**KIRKLEES METROPOLITAN COUNCIL
INVESTMENT & REGENERATION SERVICE**

Reference No: 2020/62/92518/W

Site Address: 7 , Royd Croft, Quarmby, Huddersfield, HD3 4EQ

Description: Erection of two storey side extension

south west elevation

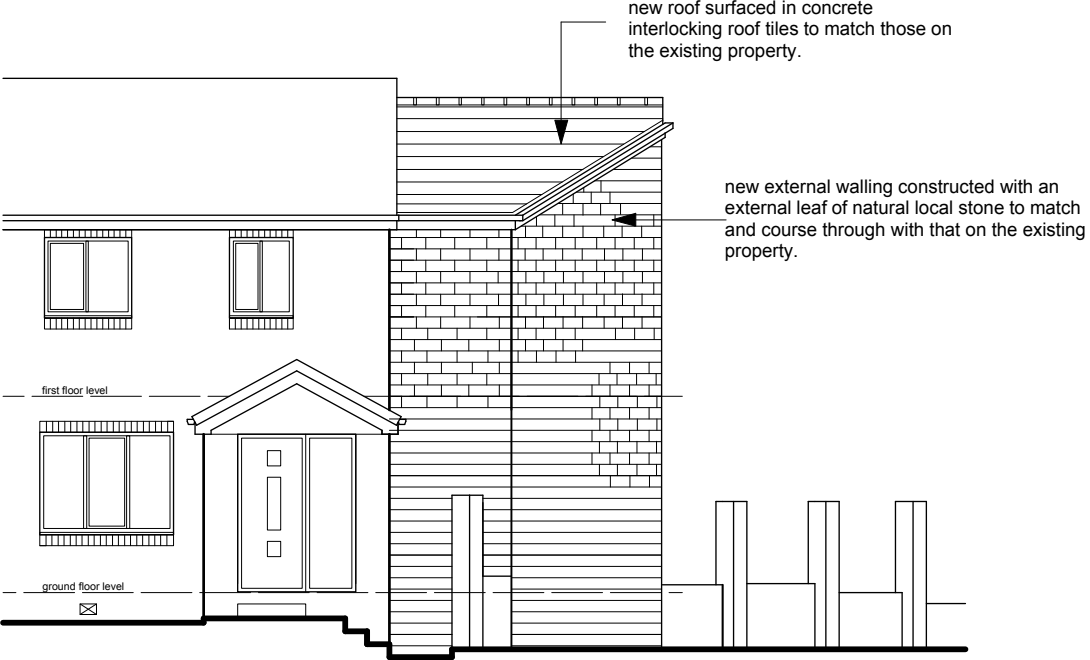
2 – Impact on visual amenity: The proposal was amended during the application process because it was considered that the combination of the splayed wall and lack of window openings in the front or corner elevation would relate poorly to the host building and its surroundings.

It is considered that the latest version of the scheme represents a substantial improvement. The front elevation no longer appears to be dominated by blank walling, and the roof overhang helps to further soften its impact. It is considered that the design, proportions and detailing of the extension would respect the host building and its surroundings. The front part of the extension appears to overlap one of the fence support columns so it is likely that two panels would have to be removed; this is not considered objectionable in planning terms since most properties on this street have open frontages anyway.

4. The roof to the extension, including the roof overhang to the south-west elevation, shall be completed in accordance with the approved plans 2020/031/03 Revision B before the extension is first brought into use and thereafter the retained as such.
